Our reference : SF14/6336; DOC18/793784
Contact : Rebecca Scrivener – 02 6773 7000 – armidale@epa.nsw.gov.au
Date : 18 October 2018

RE: Notice of Exhibition – Vickery Extension (SSD 7480)

The EPA has reviewed the Environmental Impact Statement (EIS) titled, '*Environmental Impact Statement - Vickery Extension Project*', dated 2018 and has determined that it is unable to recommend project approval conditions for the proposal due to inadequate information provided in the EIS.

Y07 - Winter Night - Receiver 131a

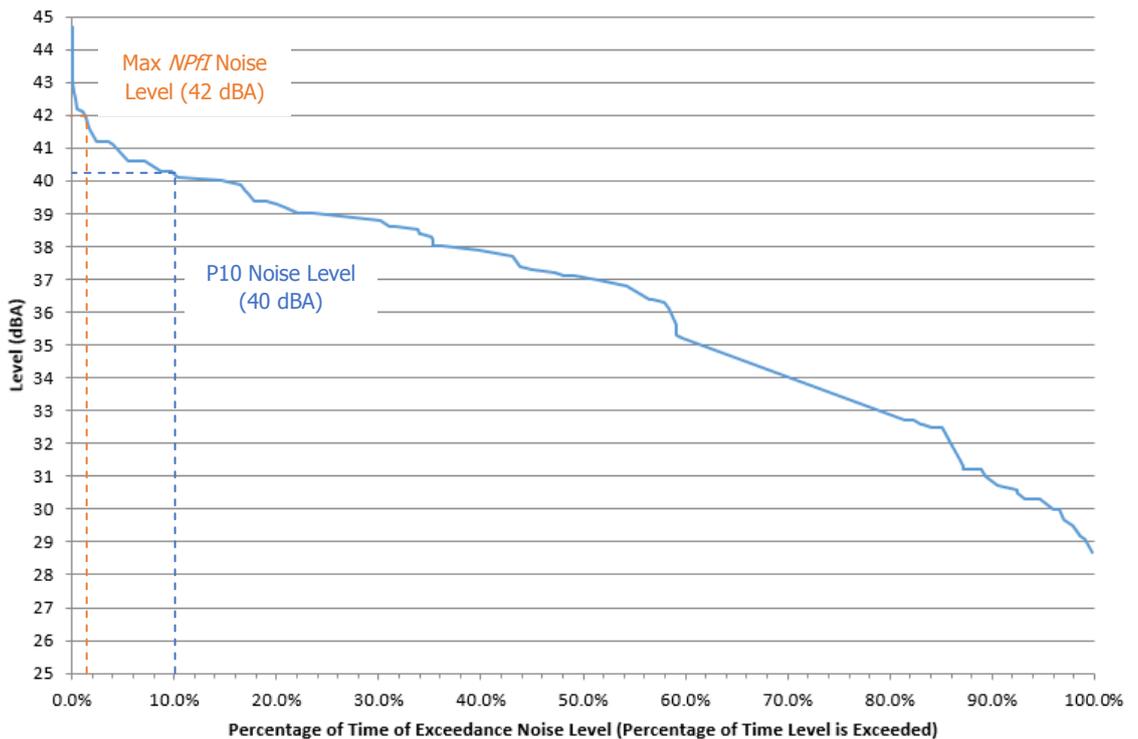
The graph in Appendix E of the NBA for Year 07-Winter Night- Receiver 131a states a P10 Noise Level of 35 dB(A), however Table 5-8 of the NBA states a corresponding value of 34 dB(A). The proponent should review and amend the information in Appendix E against Table 5-8 predictions where necessary.
